From: Slaidburn and Easington Parish Council c.o Alison Robinson
<saepcAR@outlook.com>
Sent: 09 August 2021 17:38
To: Planning
Subject: planning@ribblevalley.gov.uk FAO Adam Birkett - Consultation on planning application, 3/2021/0745, Brockthorn Wigglesworth Road Slaidburn BD23 4SX

The application is for - Proposed single storey extension to north elevation.

3987 -02A

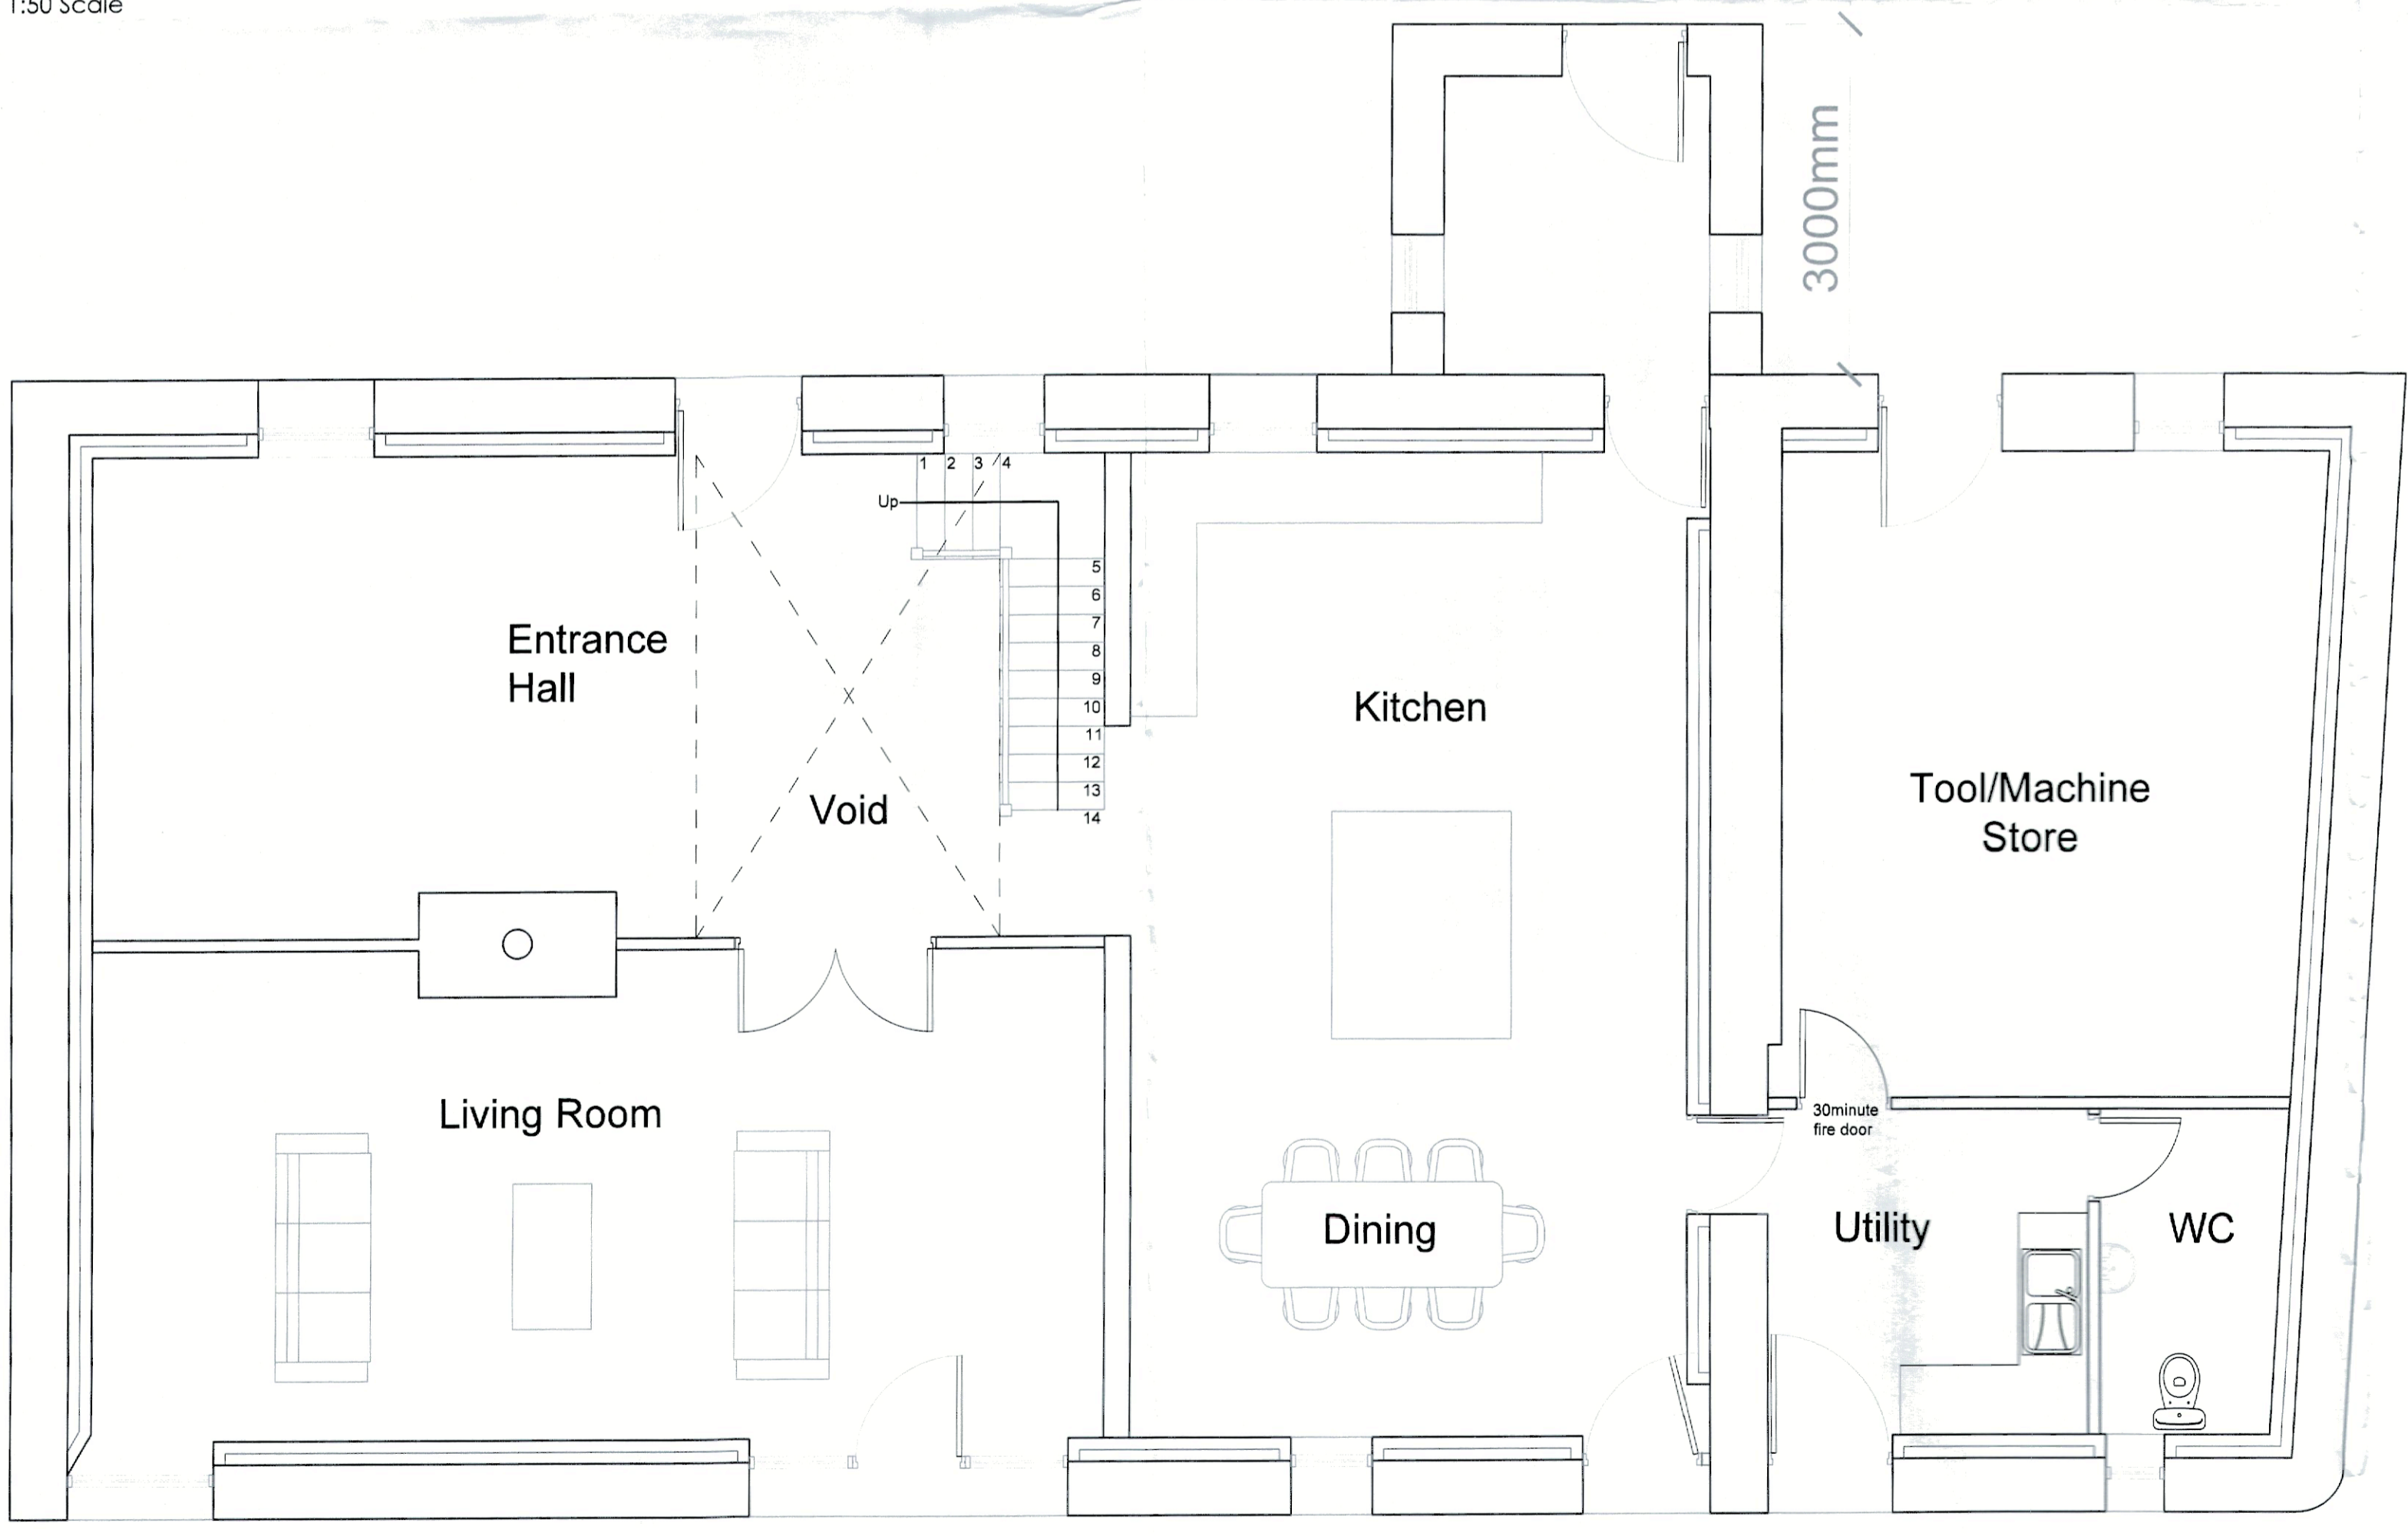
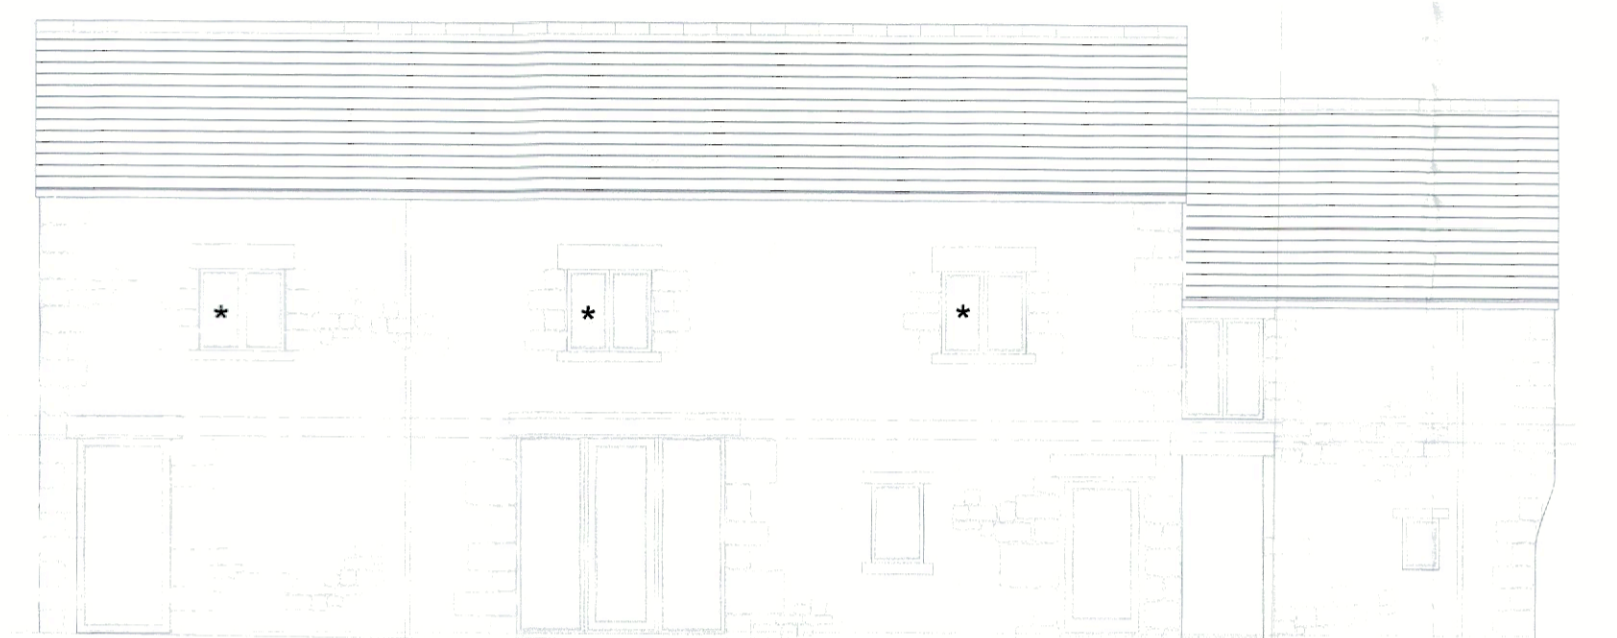
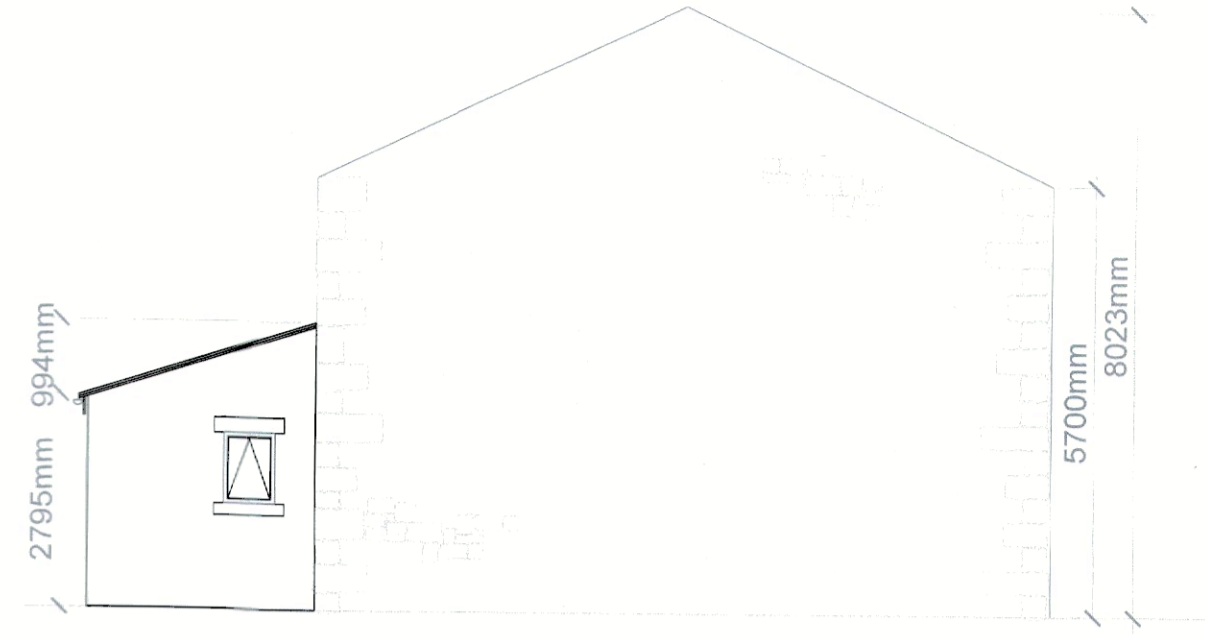
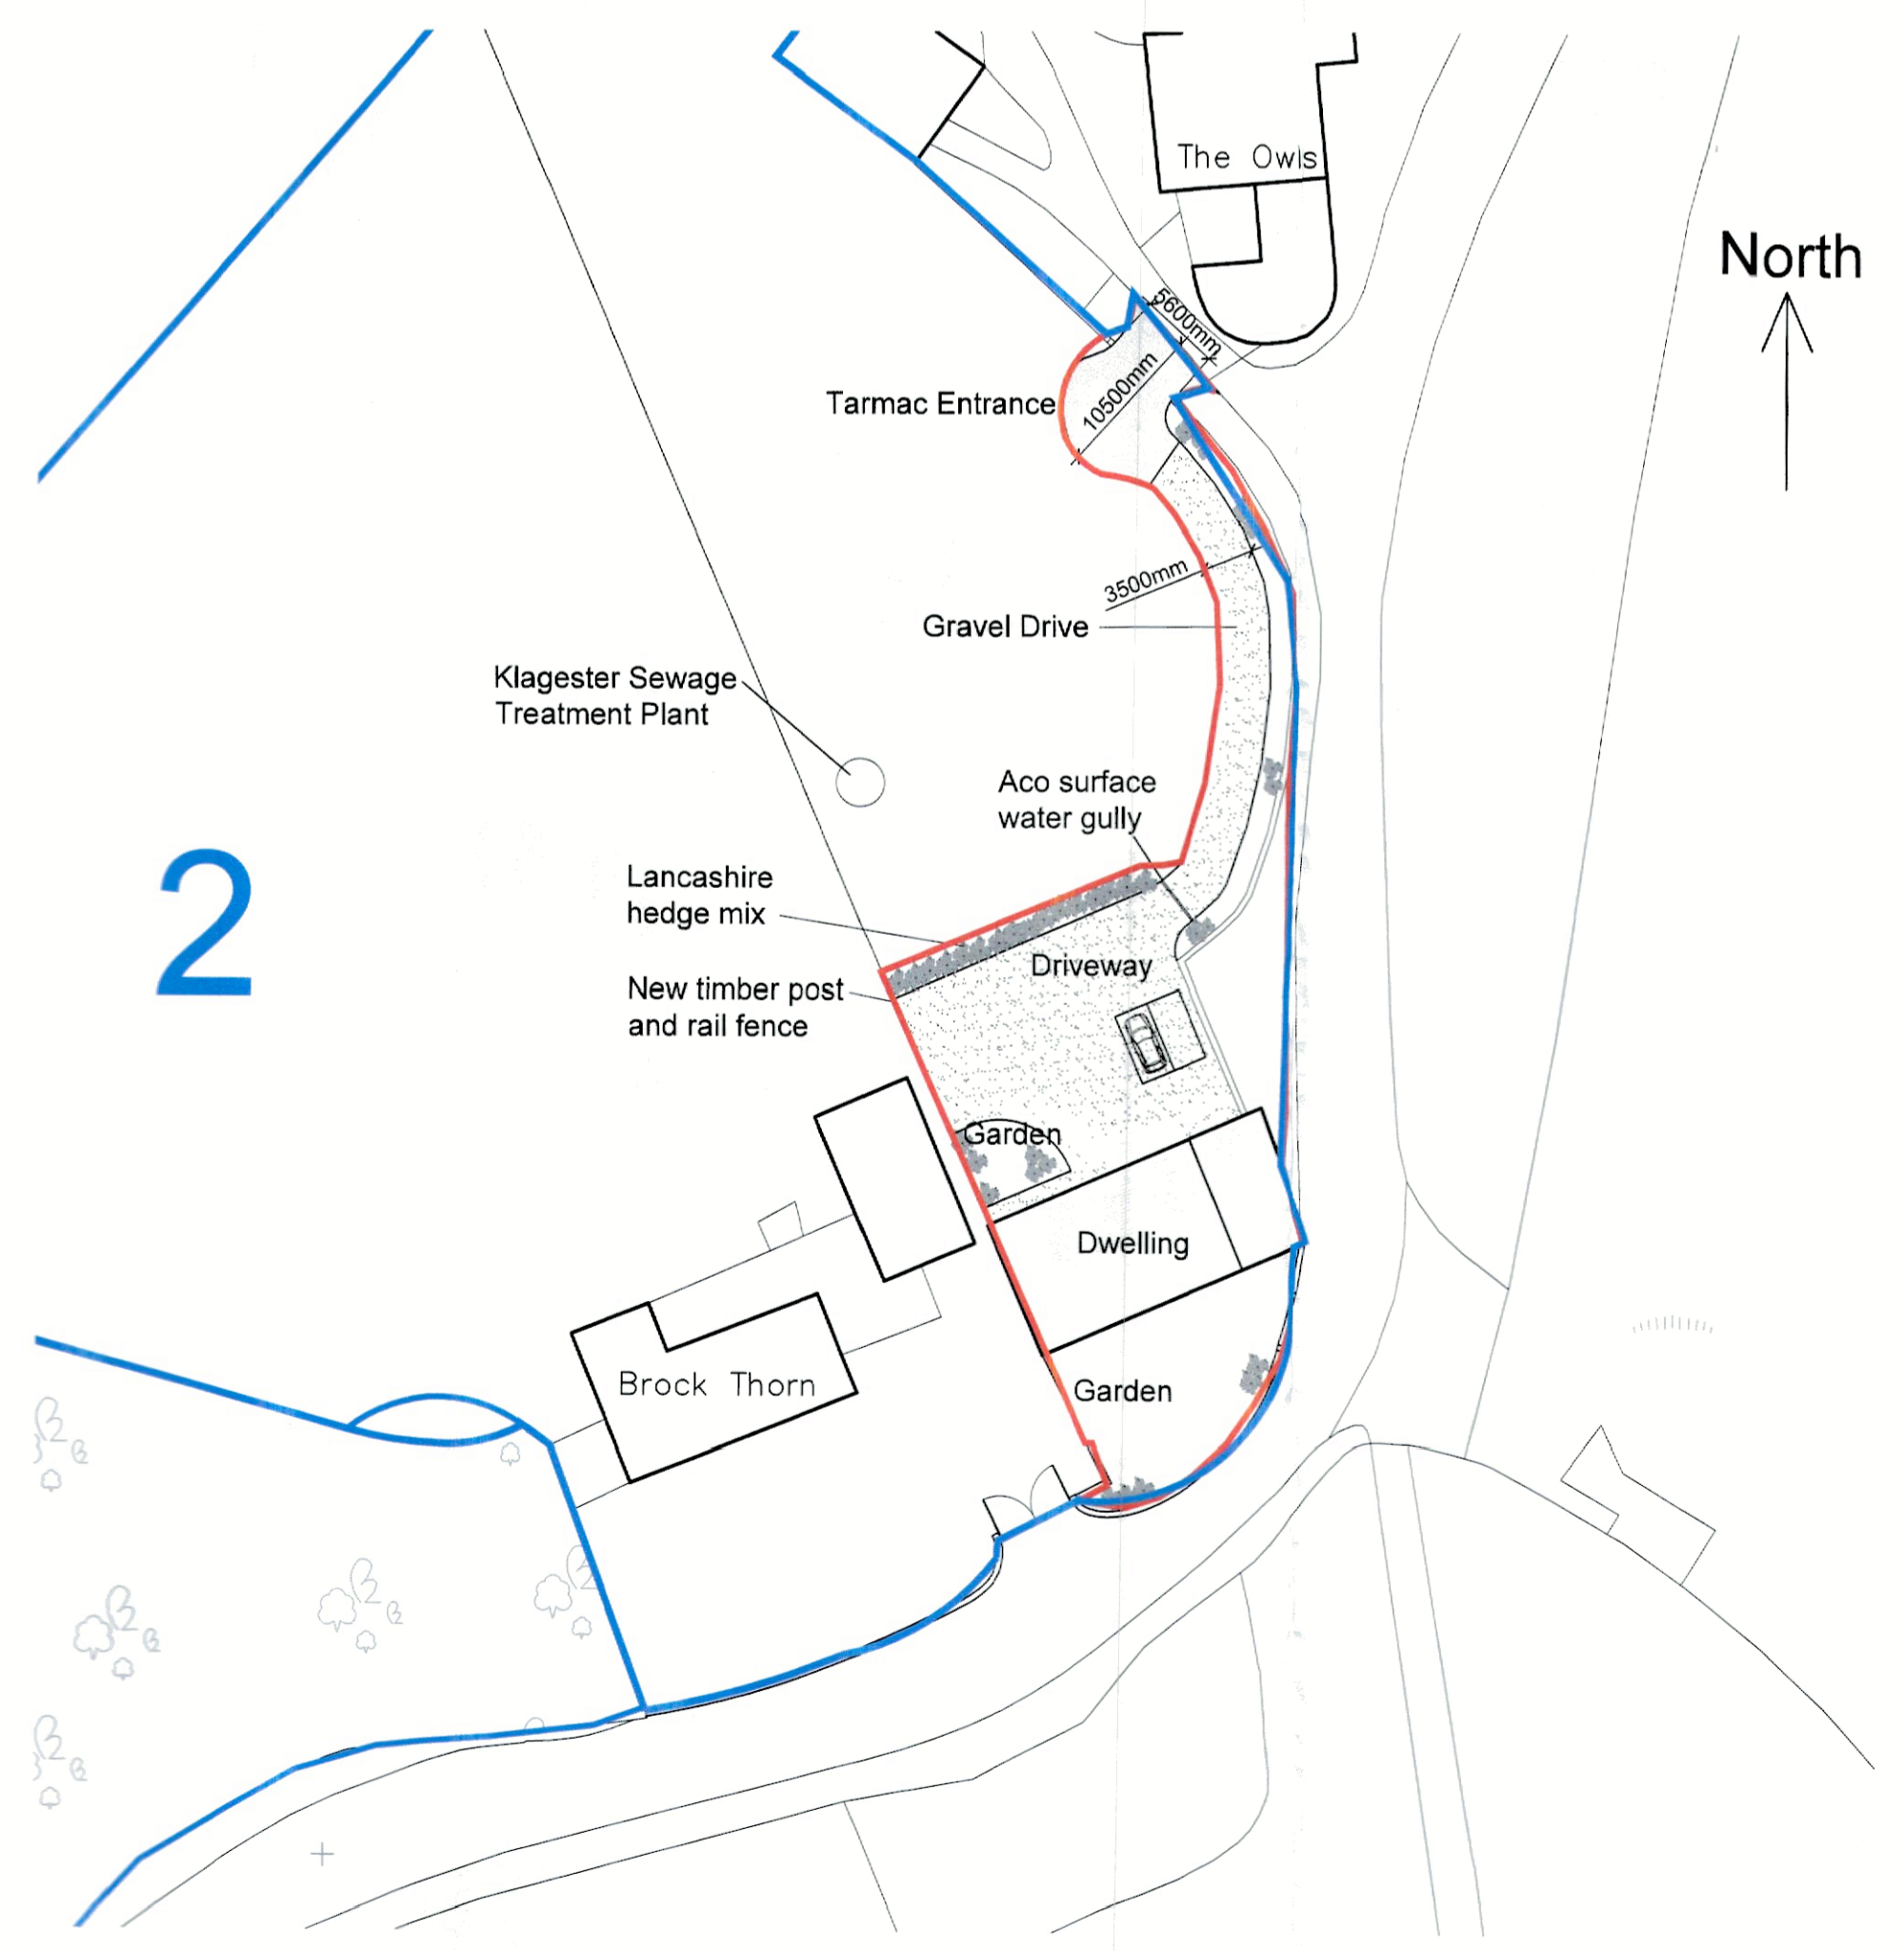
- There is no surname for the applicant on the application form.
- The plans are not clear as to where the proposed development is and whether it is intended to be part of the house or the barn.
